Our ref: HA/2022/123981/01-L01
Your ref: BN/11/22/OUT
Date: 28 March 2022

OUTLINE APPLICATION WITH ALL MATTERS RESERVED (EXCEPT FOR THE A29 REALIGNMENT) FOR THE DEMOLITION OF EXISTING STRUCTURES AND MIXED USE DEVELOPMENT TO PROVIDE RESIDENTIAL DWELLINGS (USE CLASS C3), CARE HOME/SENIOR LIVING ACCOMMODATION (USE CLASS E/F2/SUI GENERIS), A PRIMARY SCHOOL PLUS OPEN SPACE, LANDSCAPING, DRAINAGE AND ALL OTHER ASSOCIATED ANCILLARY WORKS; AND REALIGNMENT OF THE A29 AND EARLY CONNECTION TO EXISTING A29 INCLUDING CONSTRUCTION OF A NEW ROAD CARRIAGEWAY, JUNCTIONS AND ASSOCIATED INFRASTRUCTURE. THIS APPLICATION ALSO LIES WITHIN THE PARISH OF ALDINGBOURNE, AFFECTS THE SETTING OF LISTED BUILDINGS, AFFECTS THE CHARACTER & APPEARANCE OF THE EASTERGATE CHURCH LANE CONSERVATION AREA AND AFFECTS A PUBLIC RIGHT OF WAY. THIS APPLICATION IS THE SUBJECT OF AN ENVIRONMENTAL STATEMENT.

BARNHAM, EASTERGATE, WESTERGATE BEW PARCEL SC1 BARNHAM

In the absence of an acceptable flood risk assessment (FRA) we **object** to this application and recommend that planning permission is refused.

Appendix A – General Arrangement for 200m Multi-Span Option

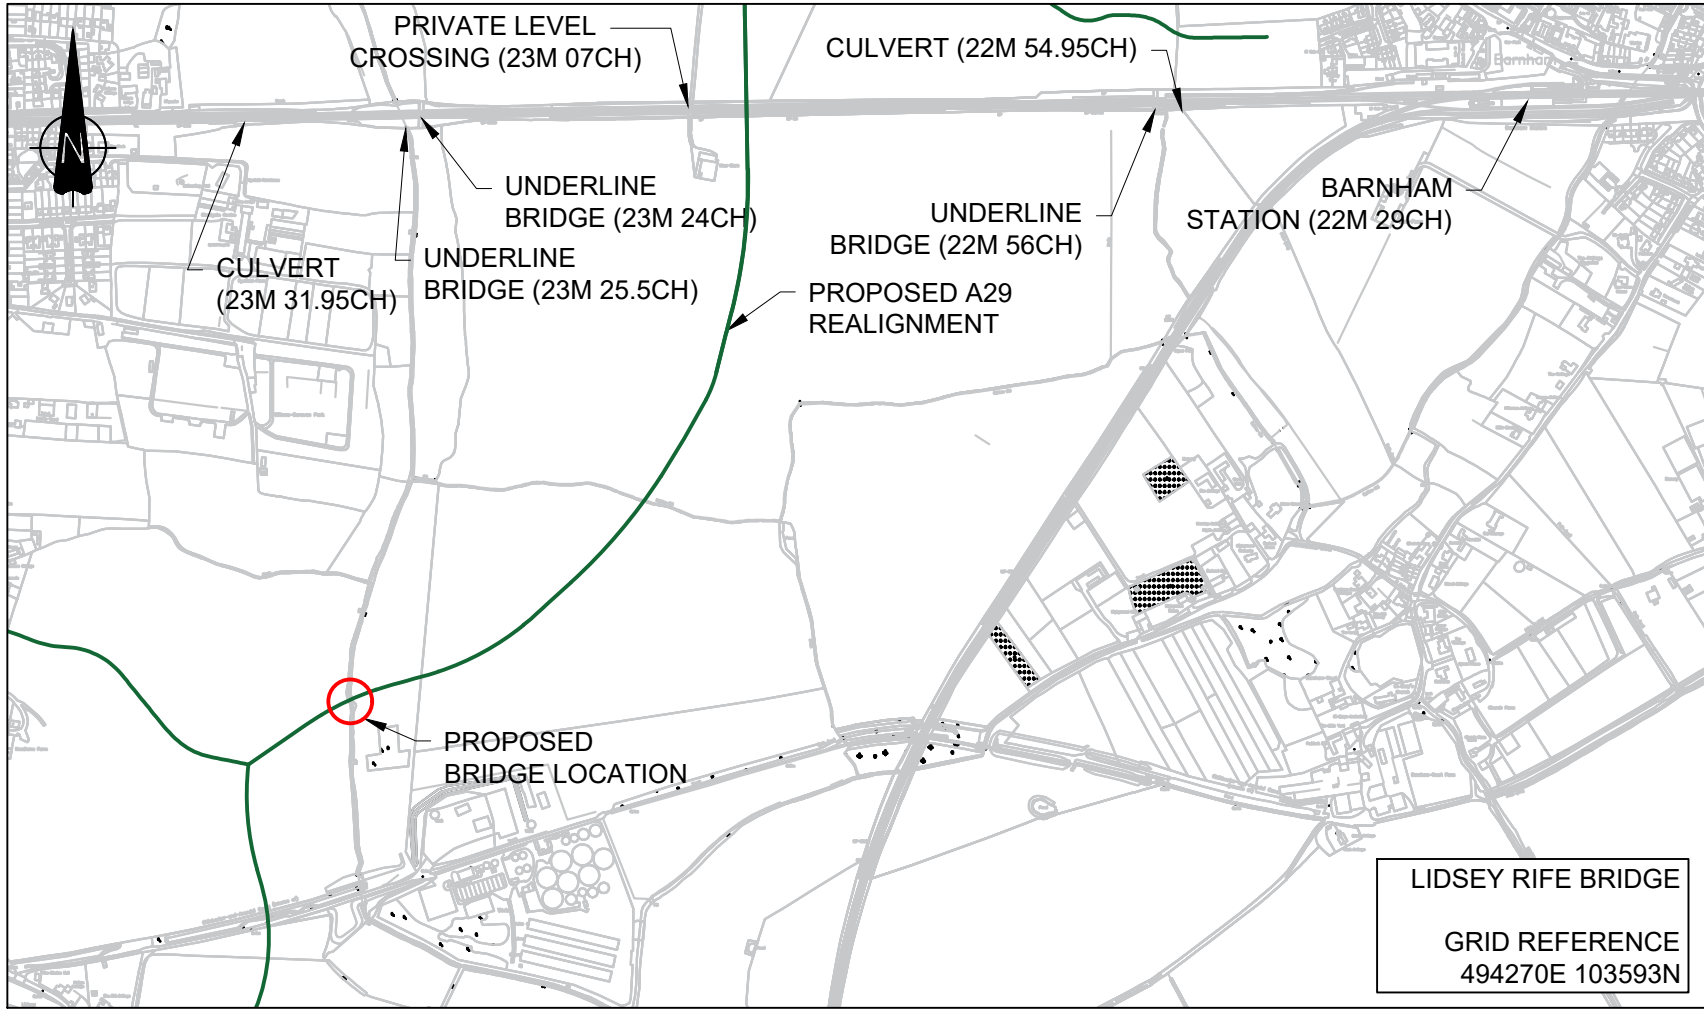
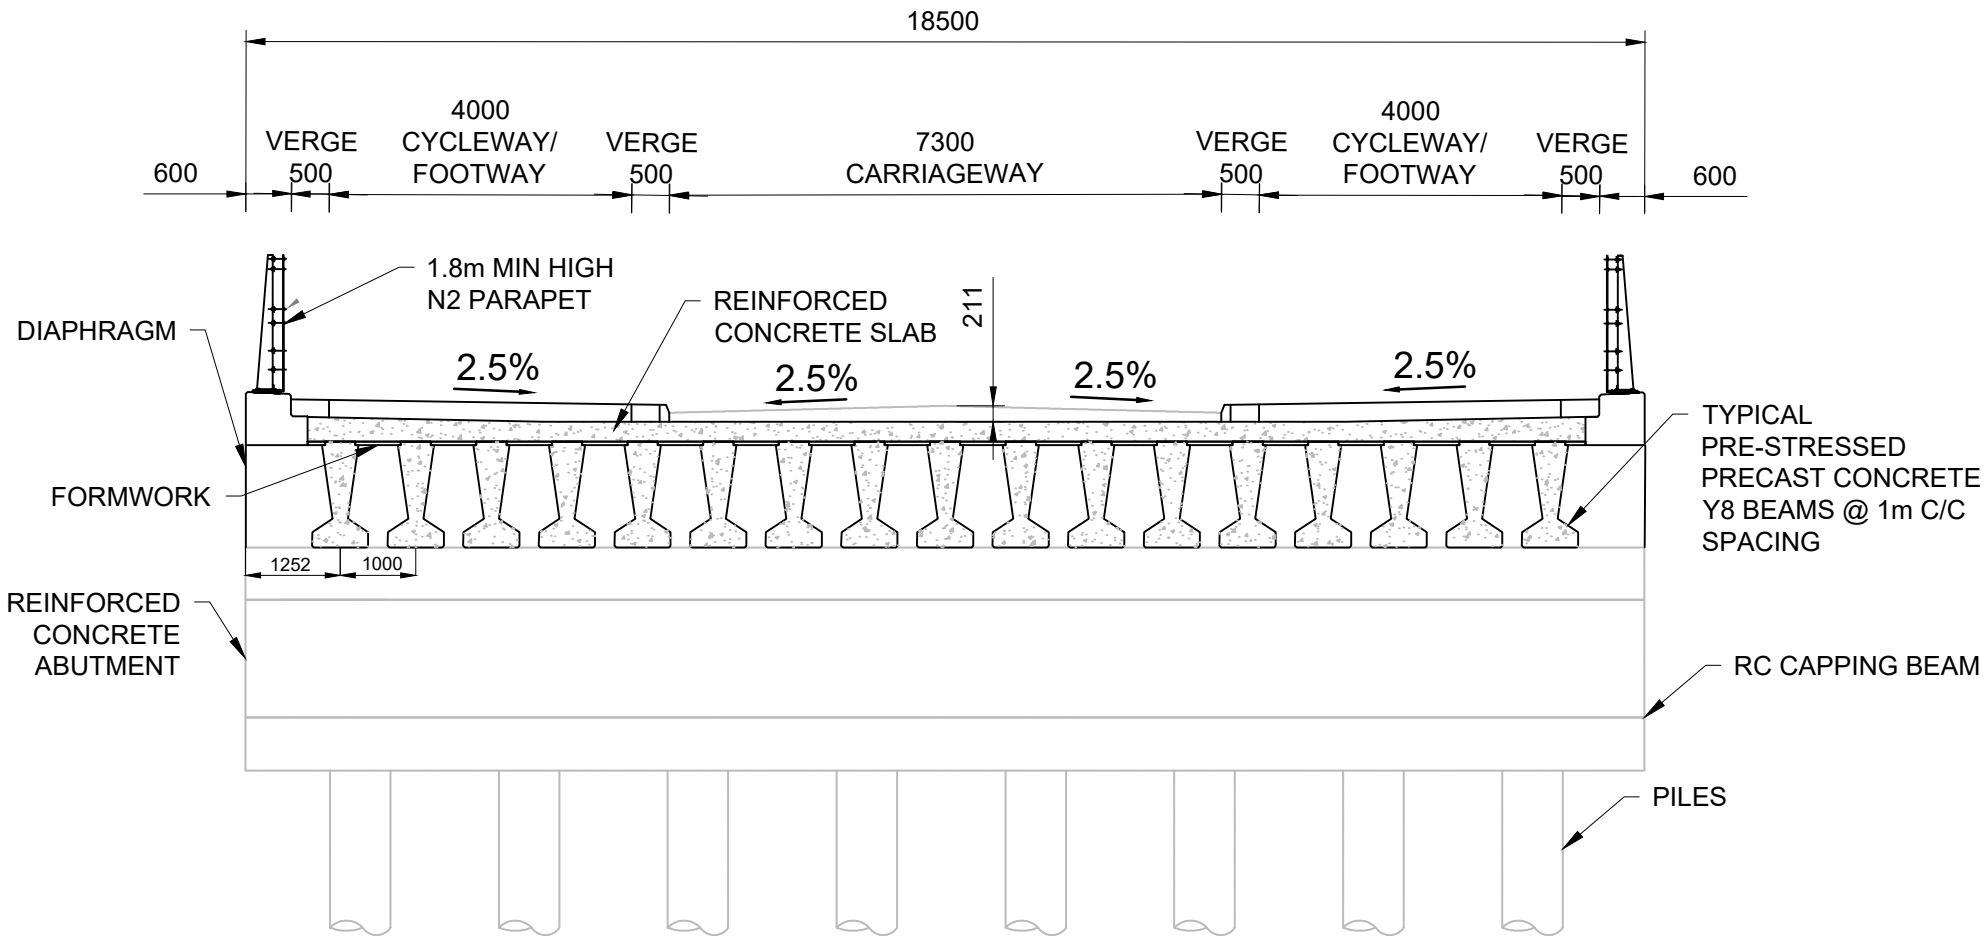
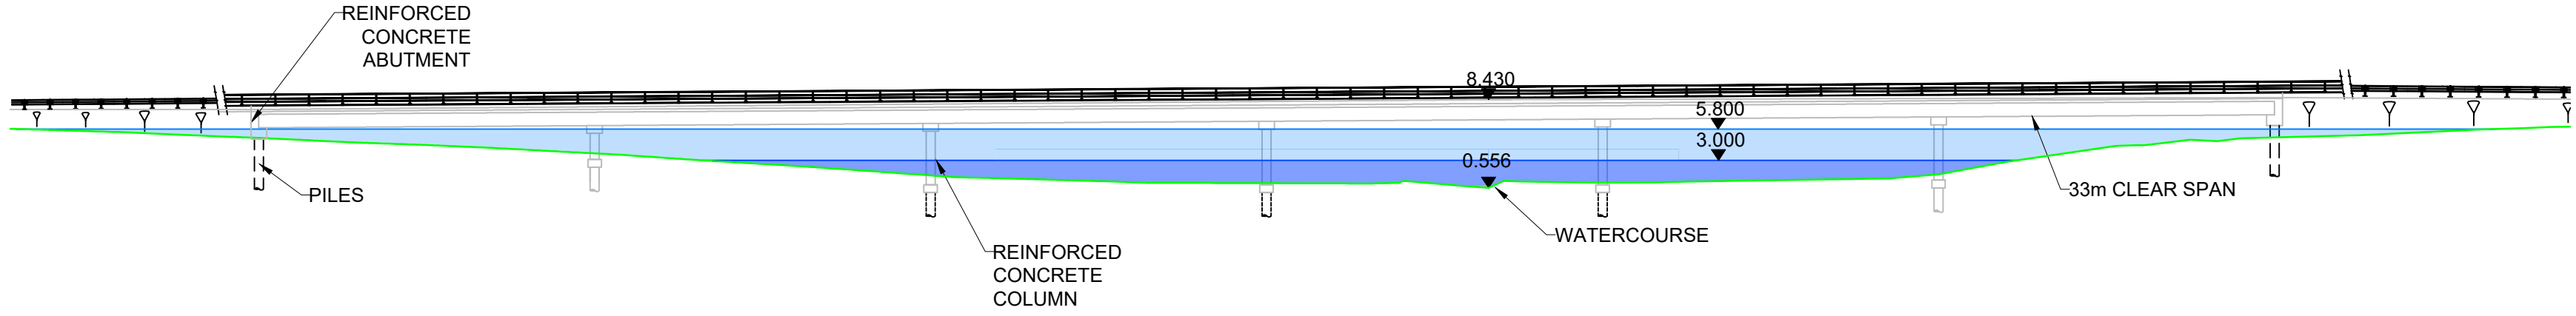
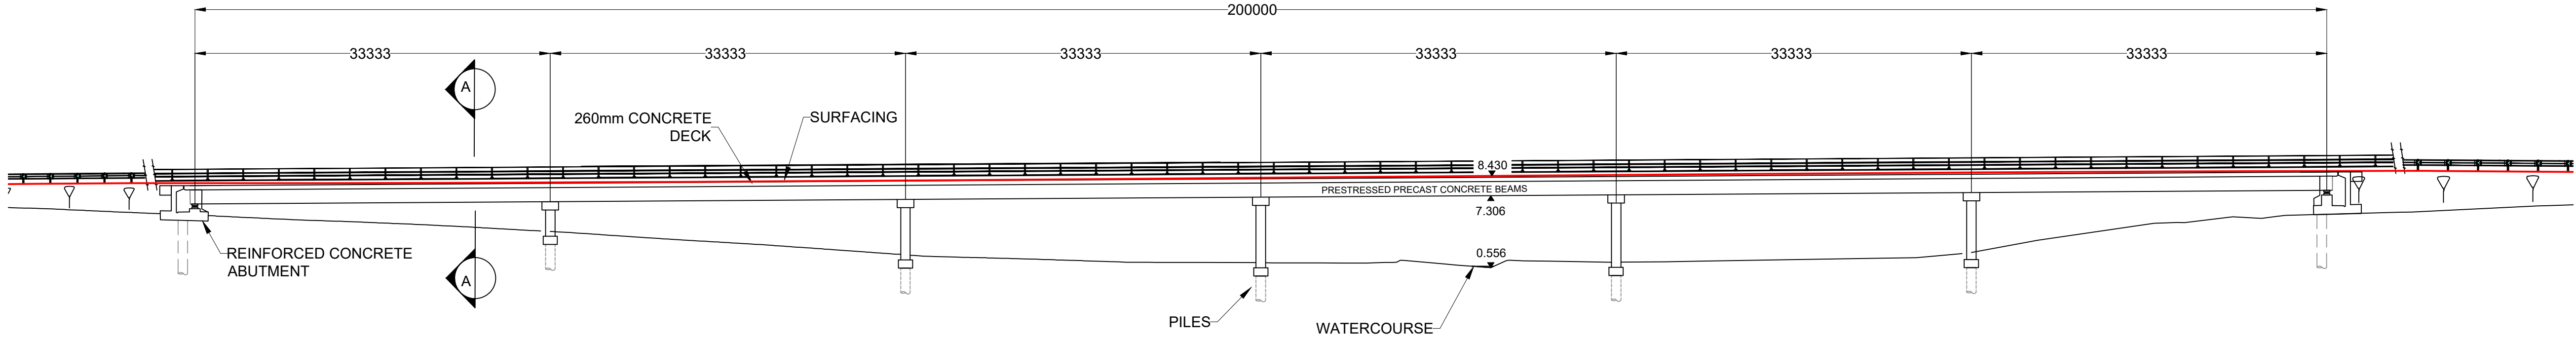
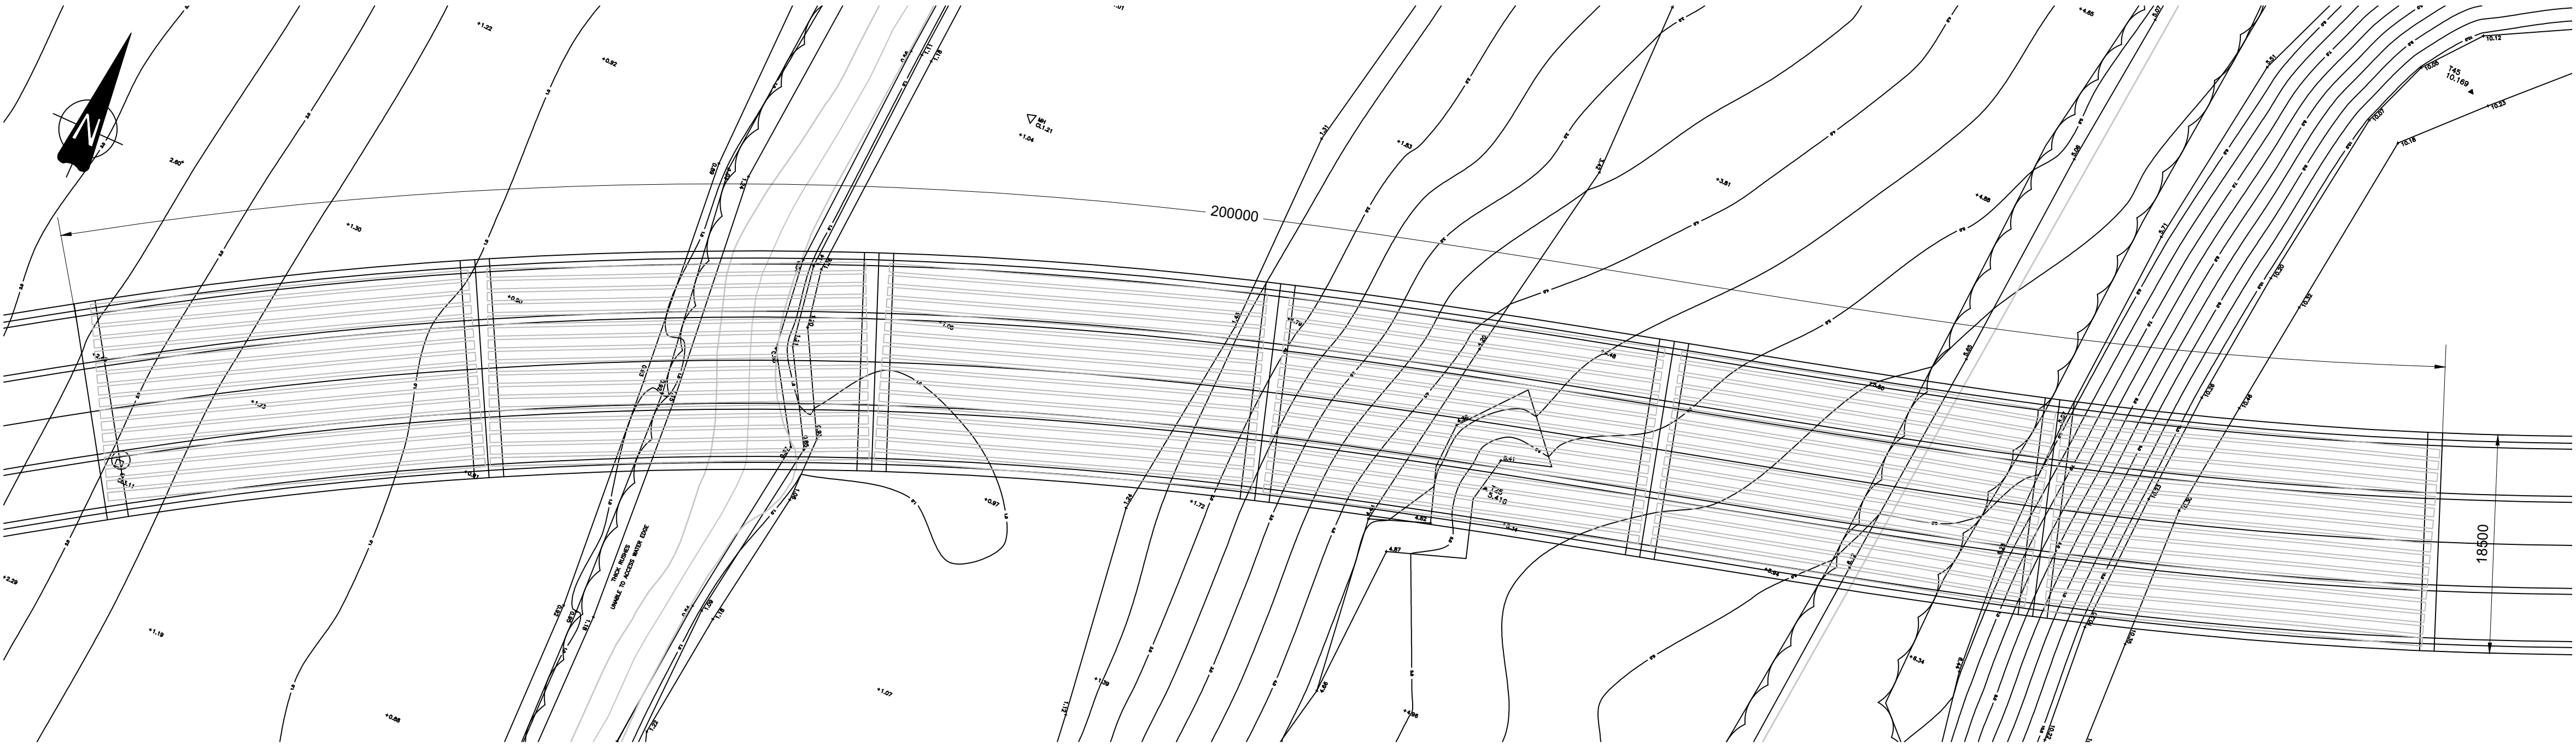
In order to assess this proposal, we would need to see reference to the latest Climate Change allowances (Flood risk assessments: climate change allowances) and their potential impact on the 200m multi-span Lidsey Rife Bridge option at multiple points.

- Outline Floodplain Compensation related to the Lidsey Rife Bridge

Floodplain compensation should fully mitigate any loss of storage. Any design should include drawings and calculations demonstrating that any loss is fully mitigated on a level for level basis. Compensation areas should be located outside the design flood extent and any flood risk impacts presented. Drawings and calculations should be signed off by the Environment Agency.

On top of these above concerns, we would expect that the approaching embankments as part of the 200m multi-span Lidsey Rife Bridge would be **located outside of FZ2/3** and would appreciate clarification on this point, if this is not possible adequate flood plain compensation should be provided.

Hydraulic modelling should be undertaken to demonstrate that the river crossing and road embankments will not increase flood risk elsewhere. The EA will need to review the modelling information before the FRA can be accepted, and this can take up to 8 weeks.

To overcome our objection, the applicant should submit a revised FRA and amended plans which addresses the points highlighted above.
